Department of  
Primary Industries

**TOLL-IPEC Warehouse and Distribution Centre, Eastern Creek (SSD12\_5705)  
Response to exhibition of Environmental Impact Statement**

Landscape Master Plan

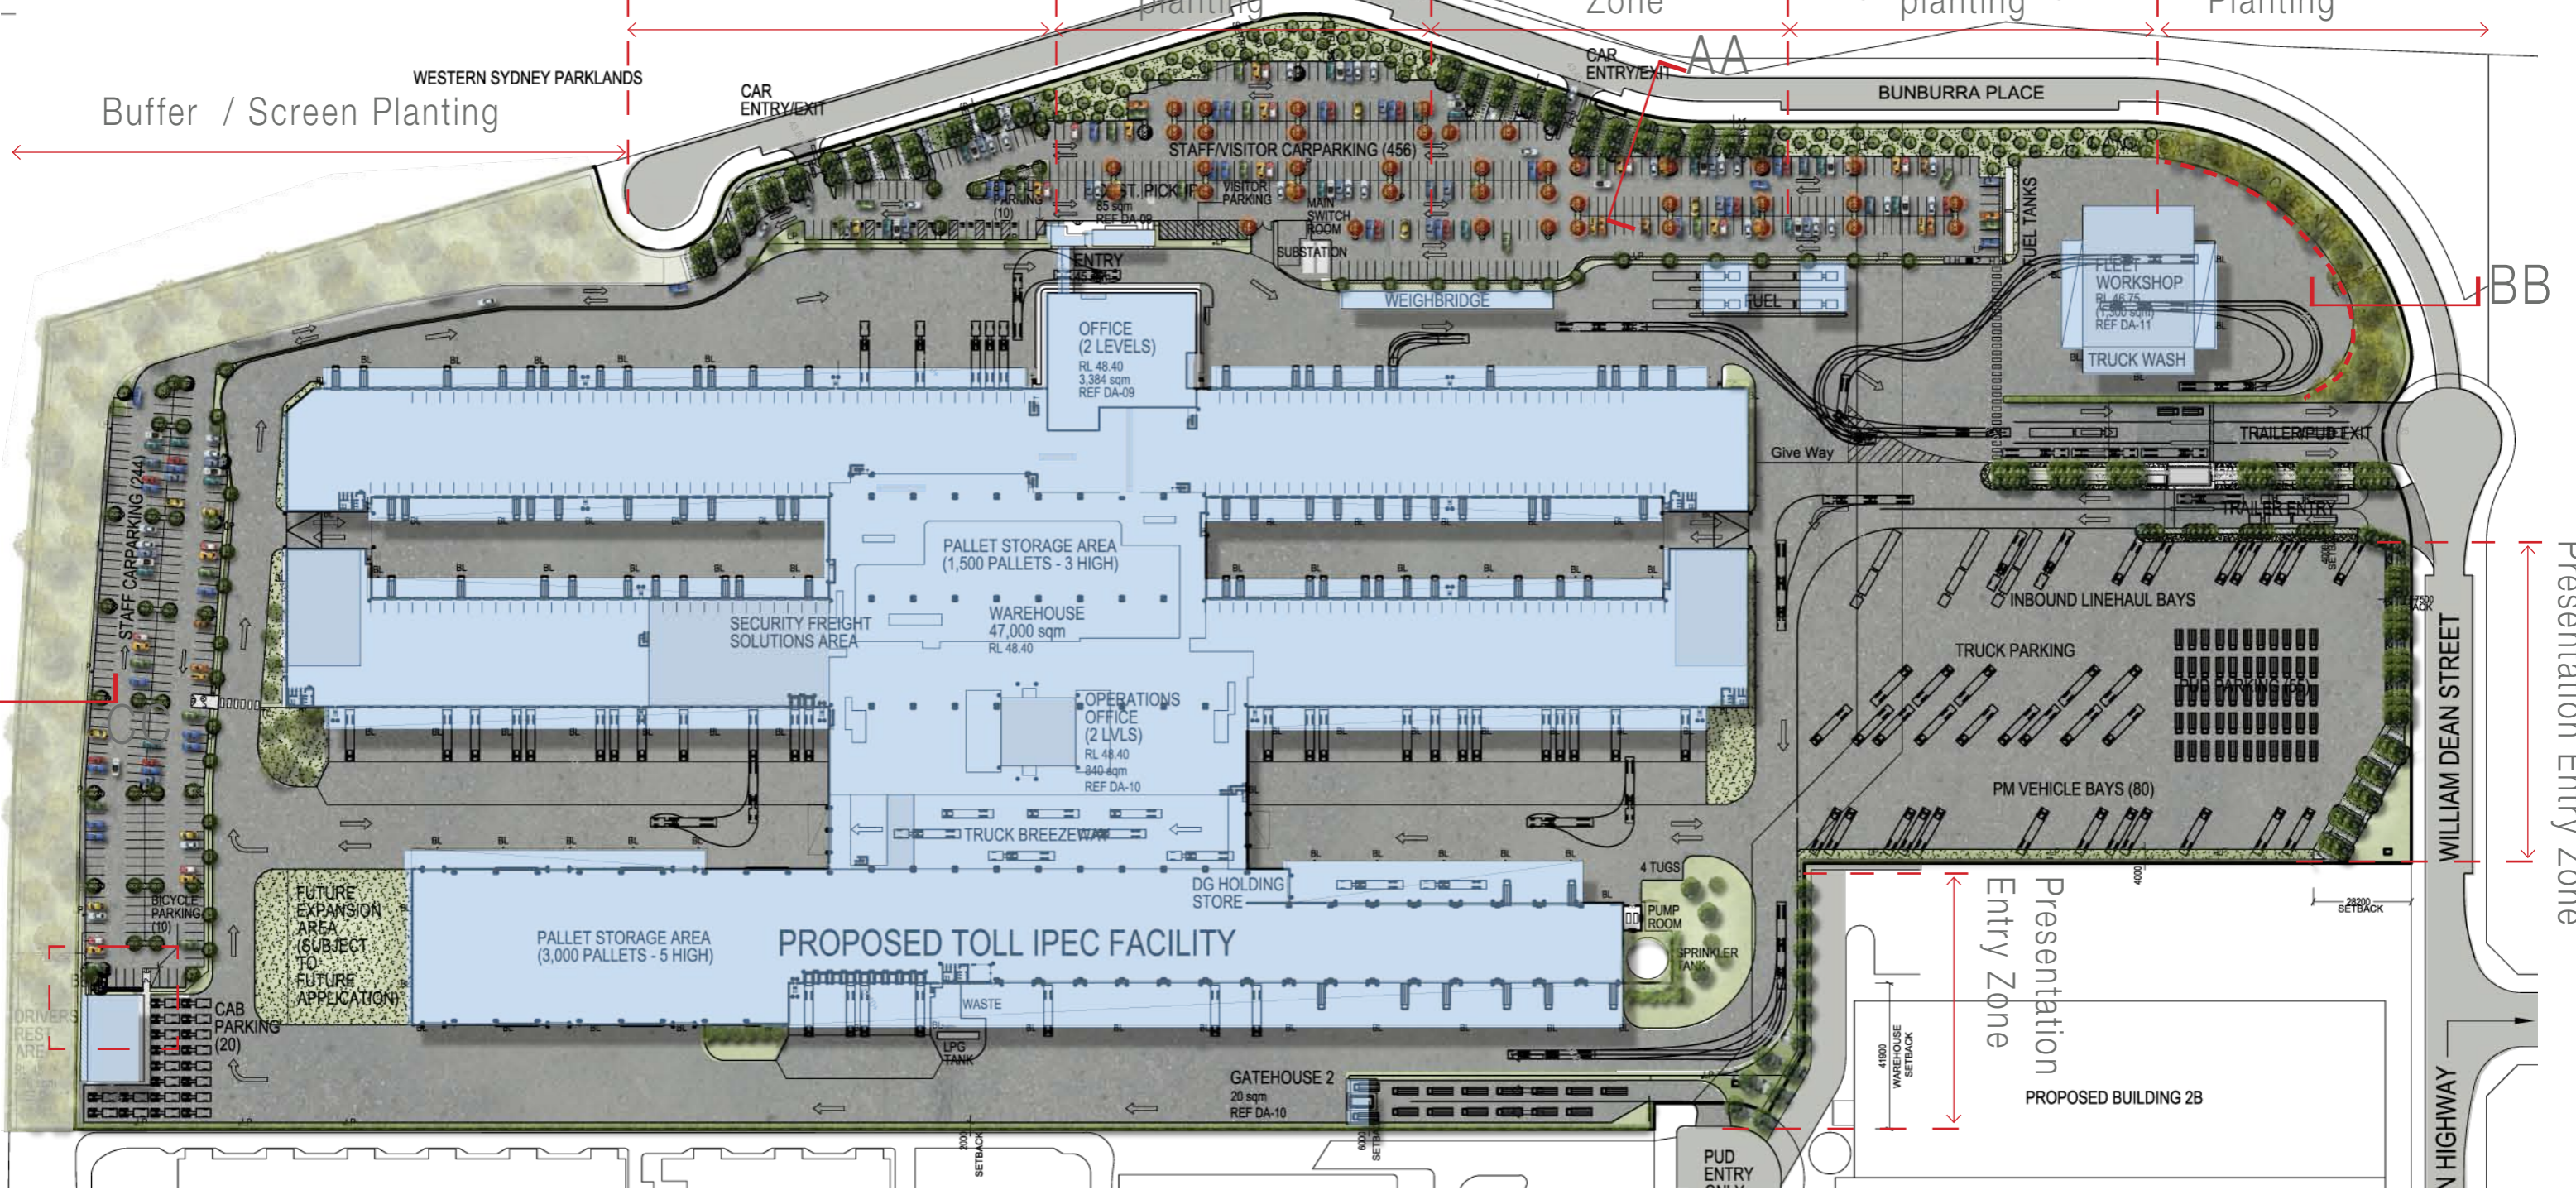
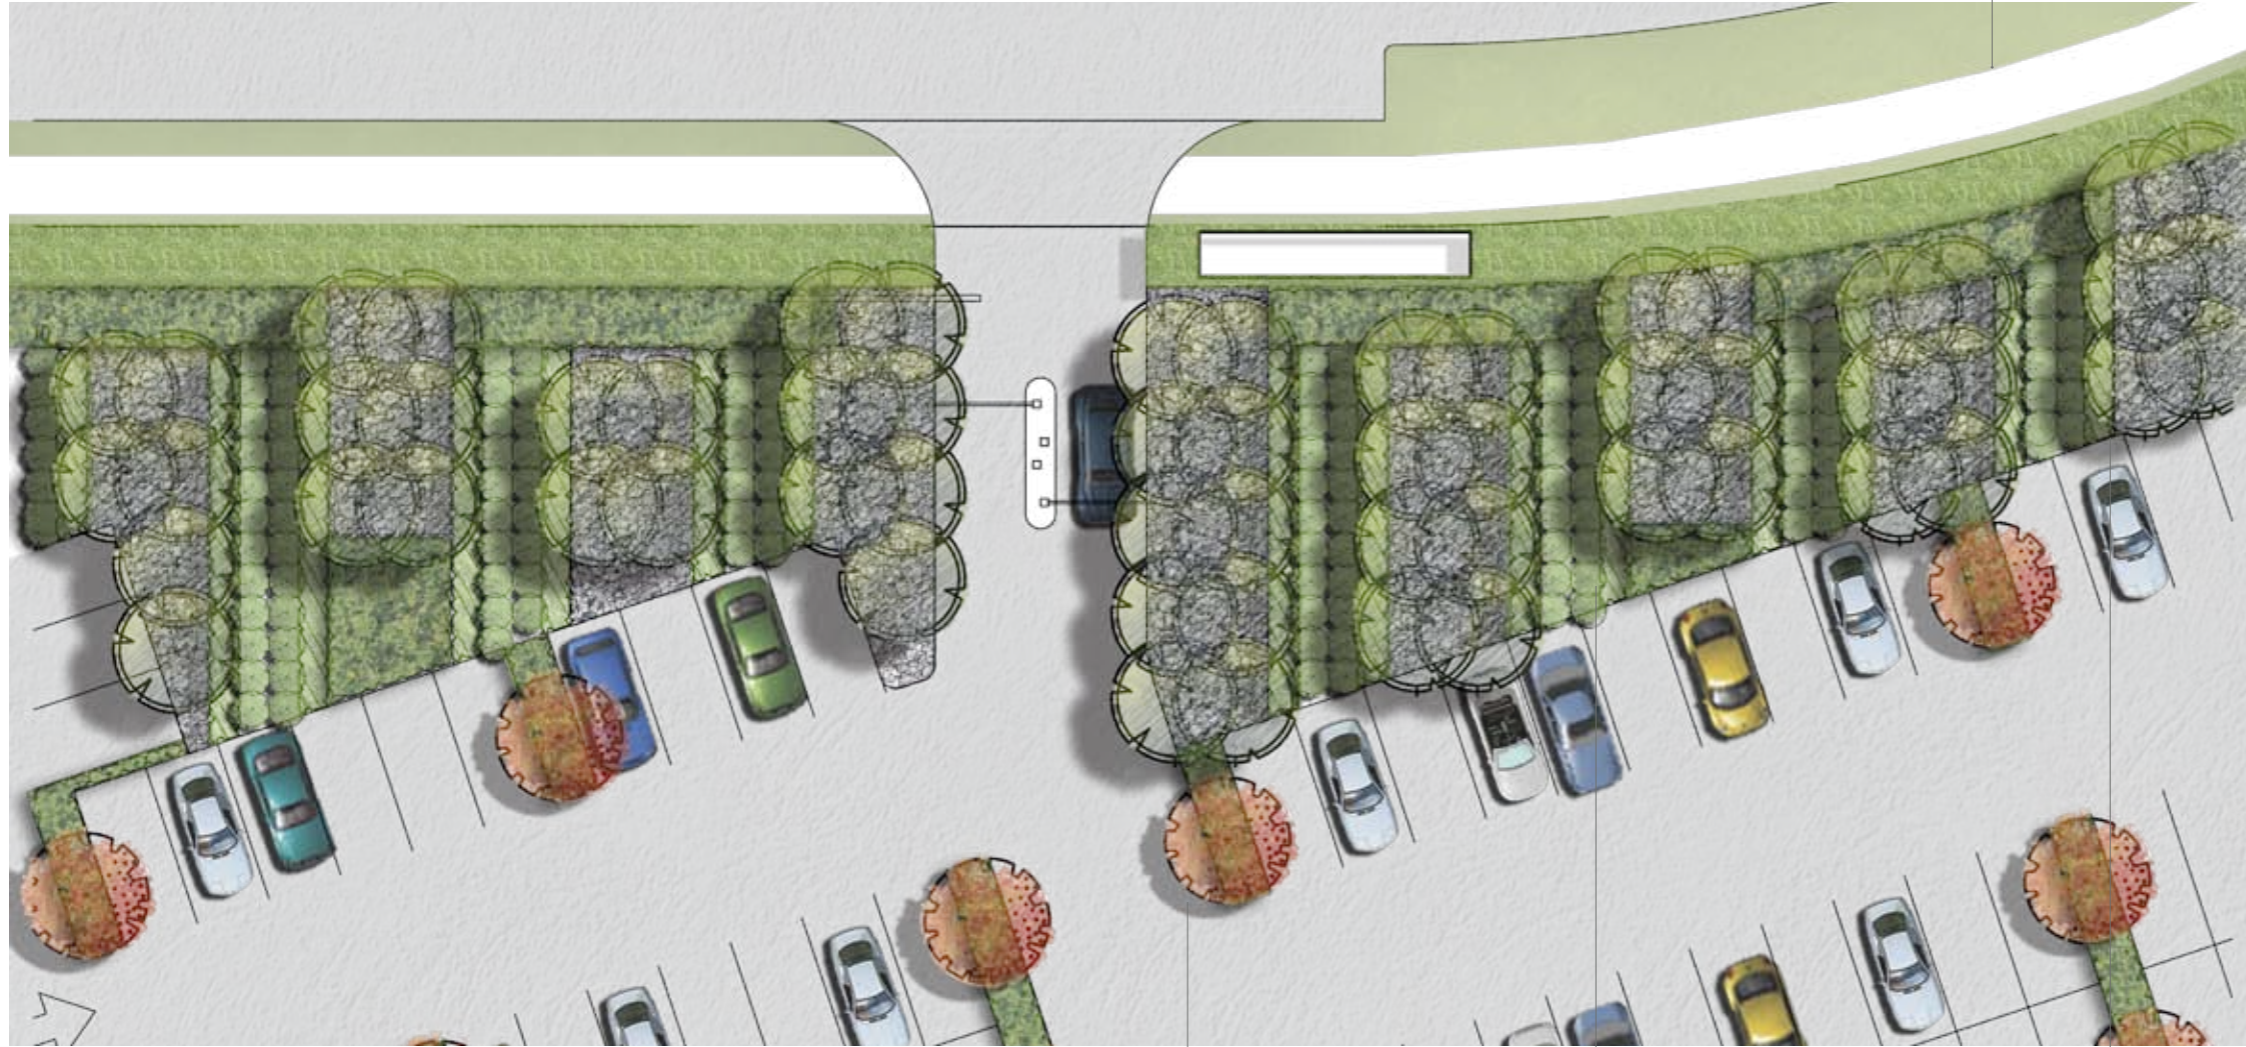
In respect to the current application, it is noted that the proposed landscaping is to use native plants which would regenerate bushland that is native to the local environment (pages 26 and 48), and Appendix D (*Huntingwood West Development Design Controls Compliance Table*) indicates the front setback is to be 100% landscaped with endemic Cumberland Plain Woodland species (see section 4.6.8).

The use of local native species will assist to improve local biodiversity and will also have lower water demand requirements. Their use on this site is supported, particularly as it is in close proximity to the Eastern Creek riparian corridor.
